Case Reference: PAX92.324370

Re: Proposed Littleton Wind Farm, County Tipperary

Formal Objection to Proposed Development

Client:			
Drawing Status:	FOR PLANNING		
Project Title:	LITTLETON WIND FARM		
Drawing Title:	FIGURE 12-1: SHADOW FLICKER STUDY AREA AND RECEPTORS		
Scale:	1:40,000	Original Size:	A3
Drawing Number:	IE00402-002

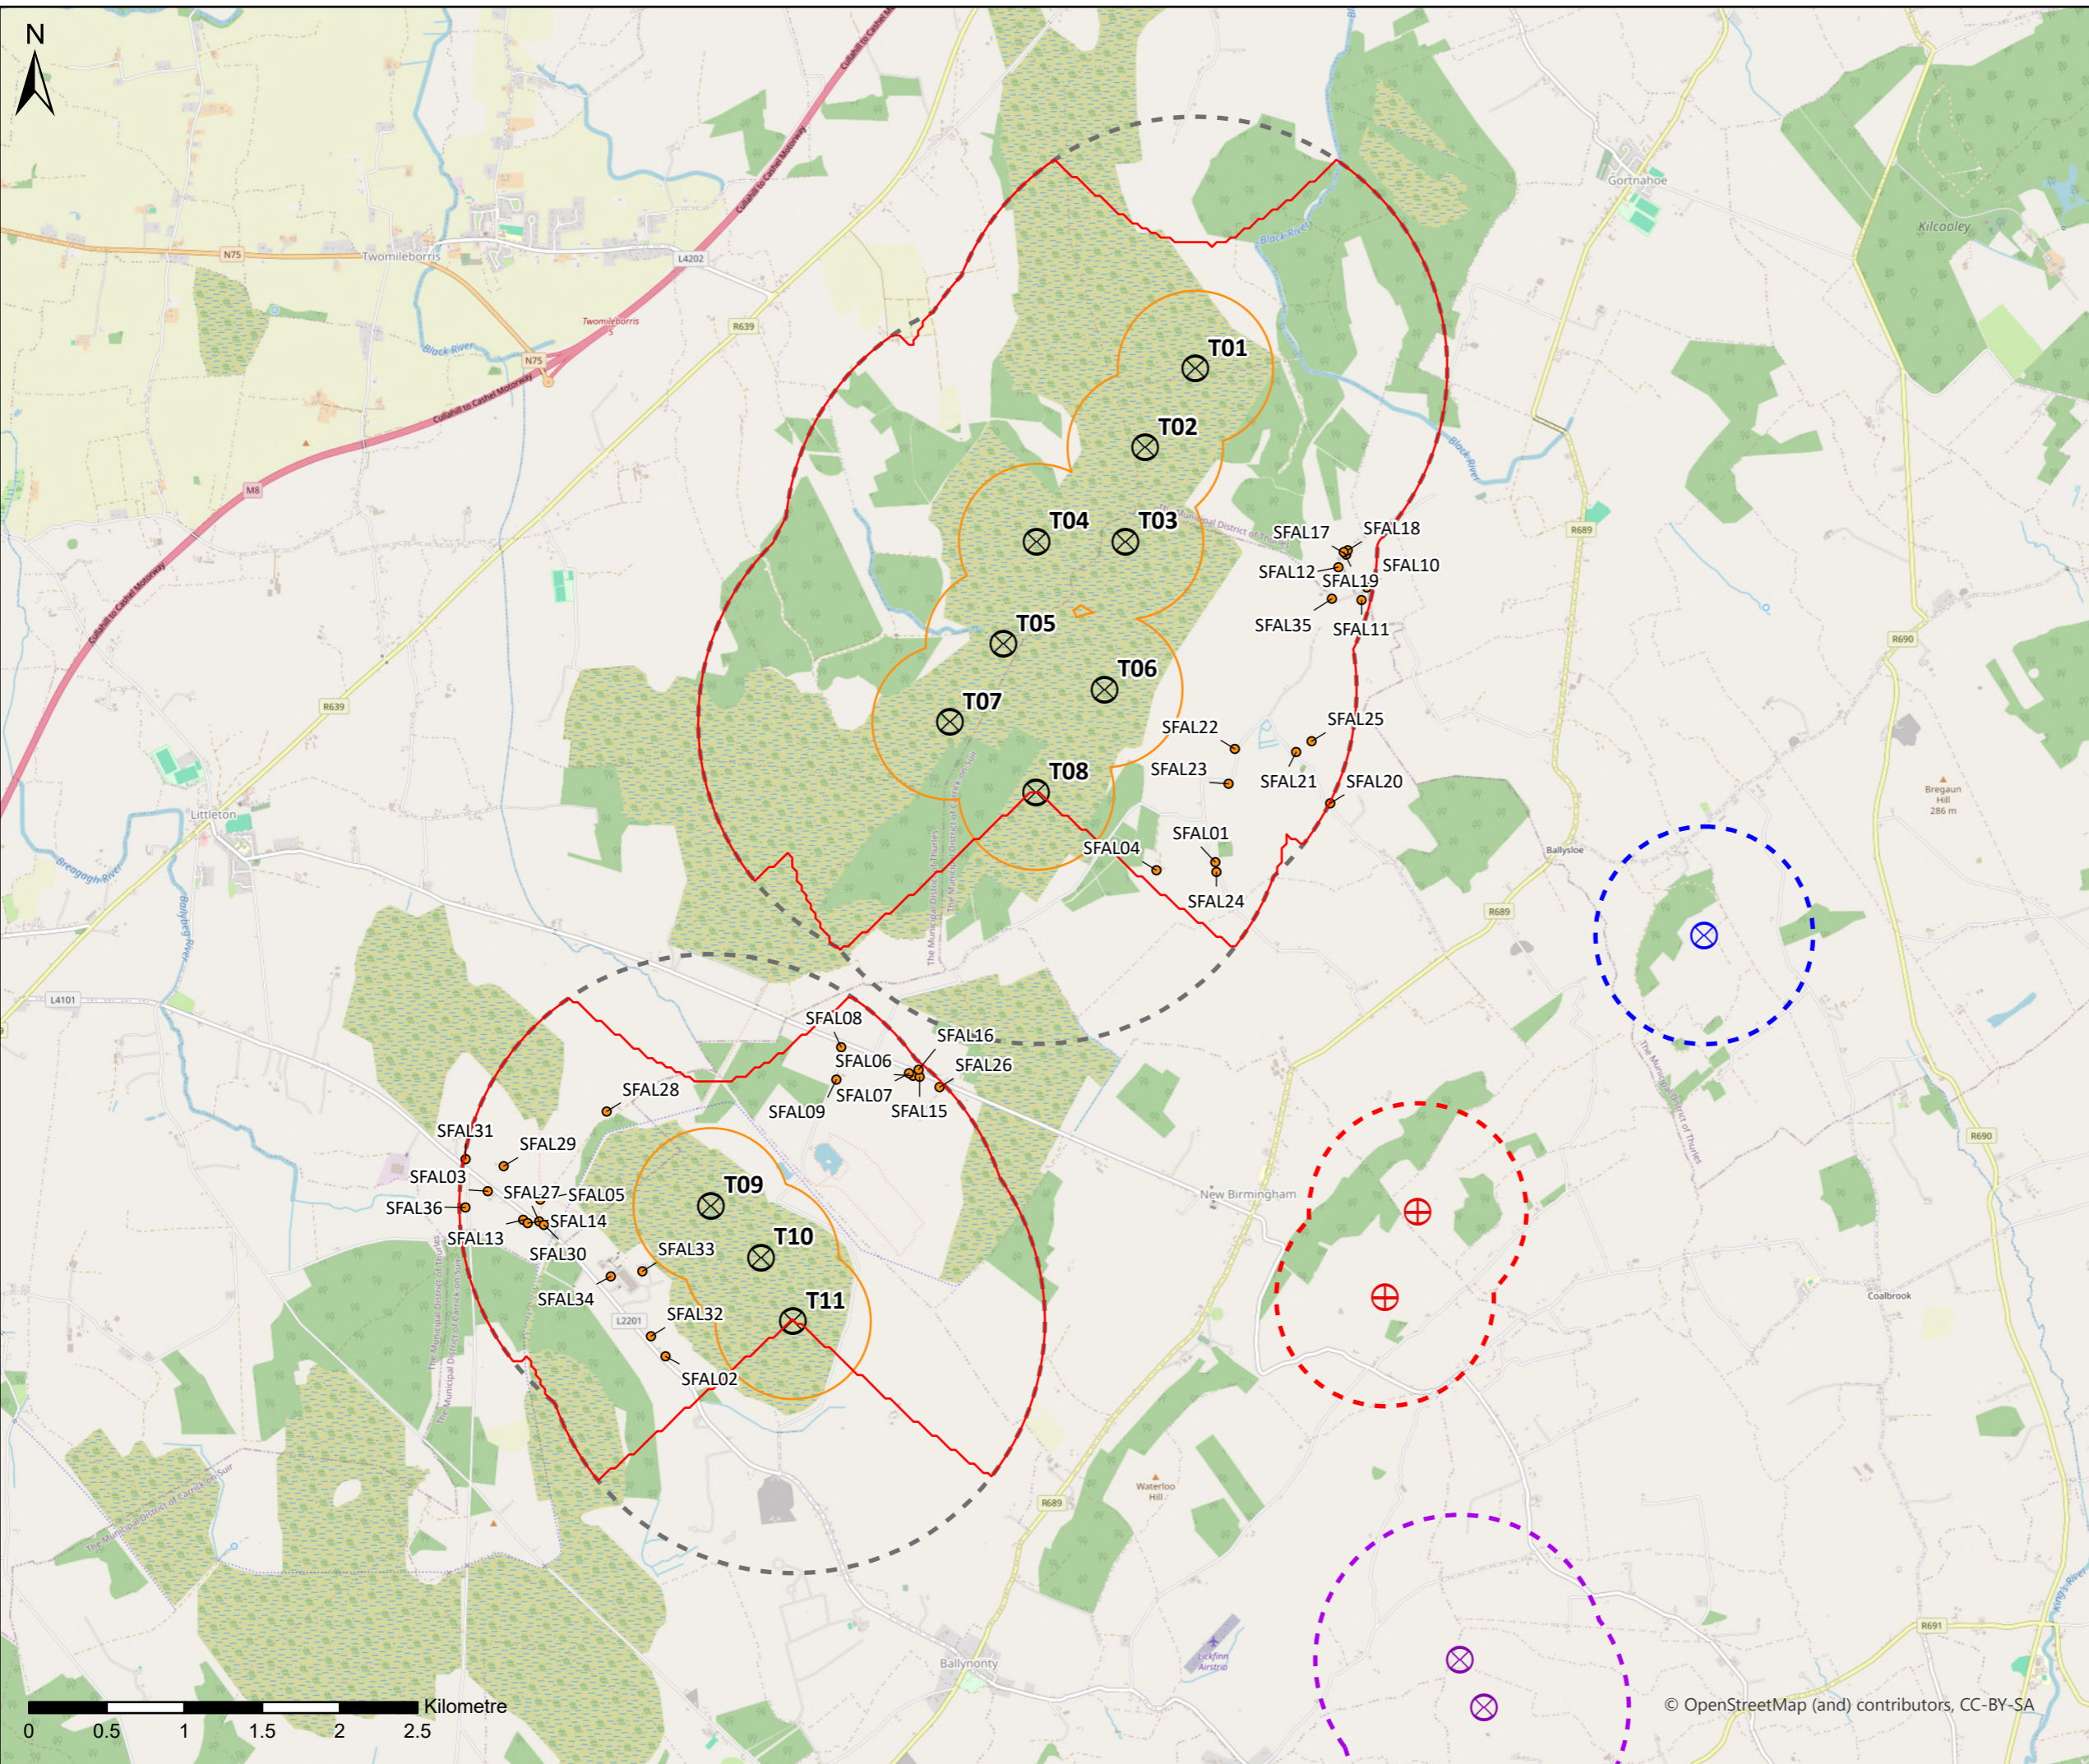
Of particular concern is that the applicant's Shadow Flicker Assessment identifies a cluster of residential receptors in the immediate vicinity of this location.

The closest identified receptor is **SFAL26**, at approximately 160 metres from the supplied location.

- SFAL15 – approximately 267 metres;
- SFAL16 – approximately 277 metres;
- SFAL6 – approximately 310 metres; and
- SFAL7 – approximately 337 metres.

I cannot establish from the publicly available application documents whether one of these receptor numbers represents my dwelling itself or an adjoining property.

I therefore specifically request that An Coimisiún Pleanála require the applicant to identify:

1. which Shadow Flicker Assessment Location corresponds to E41 KA00;
2. the exact coordinates used for that receptor;
3. the distance and bearing from the property to each relevant turbine;

4. which turbines contribute to predicted shadow flicker;
5. the predicted dates and times of potential shadow-flicker events;
6. the relevant façade and window orientations used in the assessment; and
7. whether the actual dwelling and its habitable rooms have been correctly represented.

This is particularly important because the applicant's modelling predicts material theoretical shadow-flicker exposure at several of these nearby receptors.

- **32 hours 26 minutes at SFAL6;**
- **30 hours 7 minutes at SFAL7;**
- **30 hours 49 minutes at SFAL15;**
- **28 hours 34 minutes at SFAL16; and**
- **16 hours 14 minutes at SFAL26.**
